Our ref: DOC21/865357-4

Your ref: SSD-6464 MOD 2

Mount Thorley – Warkworth Coal Mine - Lemington Underground Mine Water Storage Project (SSD-6464 MOD 2)

BCD's recommendations

Figure 3A: General Development Layout – Lemington Underground Mine Workings

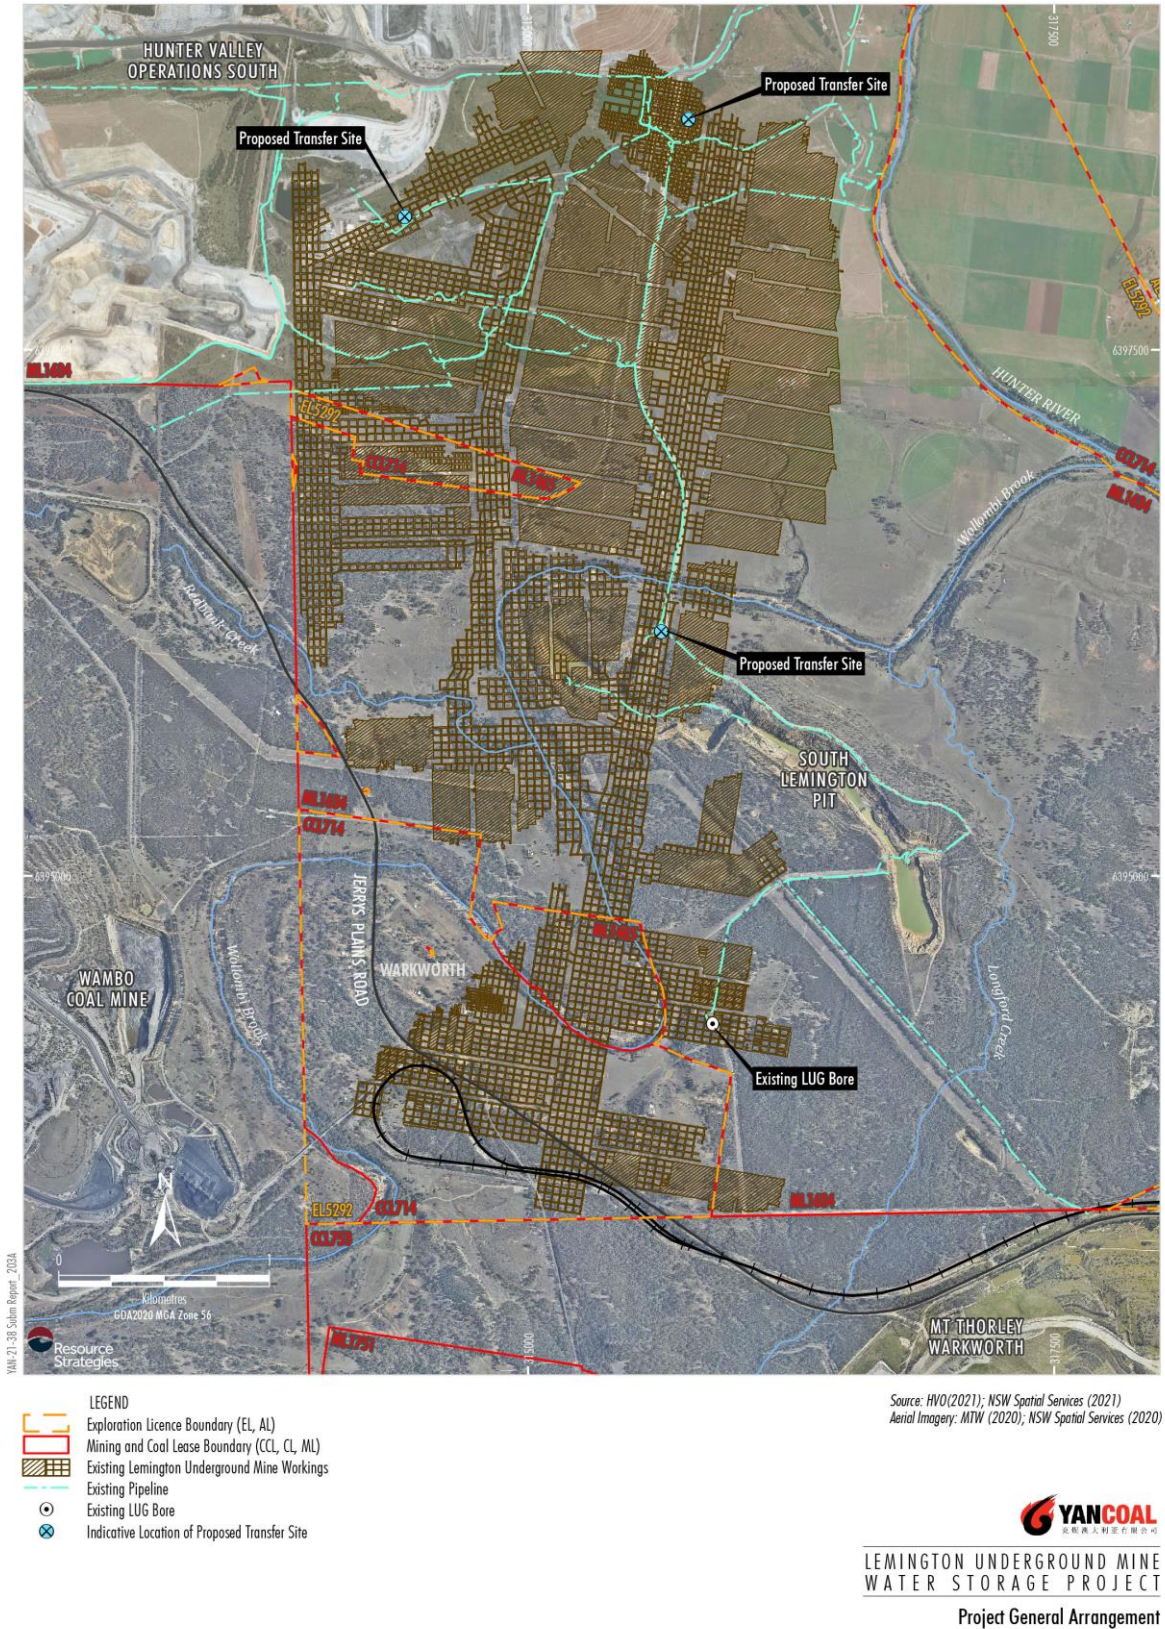
2. The proponent has not considered the impacts of repeated wetting and drying cycles on the stability of the bord and pillar mine workings

Surface disturbance from the subsidence of the old Lemington Underground Mine has the potential to expose the Hunter River, Redbank Creek and Wollombi Brook to an increased frequency of flooding or to flood risks that may not have existed previously.

It is proposed to temporarily store surplus surface water in the existing Lemington Underground bord and pillar mining void. As this water is reused in mining operations, the coal pillars will be subject to repeated wetting and drying cycles. Degradation effects due to the cycles of wetting and drying may cause flaking and the long-term reduction in the supporting areas of the pillars. Failure of the coal pillars may result in damaging subsidence of the ground surface.

The Lemington Underground Mine extends beneath the Hunter River, Redbank Creek and Wollombi Brook. Surface disturbance of the workings can impact these river courses, including changing the longitudinal stream profile gradient and streambed cracking.

Recommendation 2

BCD recommends that the proponent assess the subsidence risks associated with using the bord and pillar mining voids to store water.
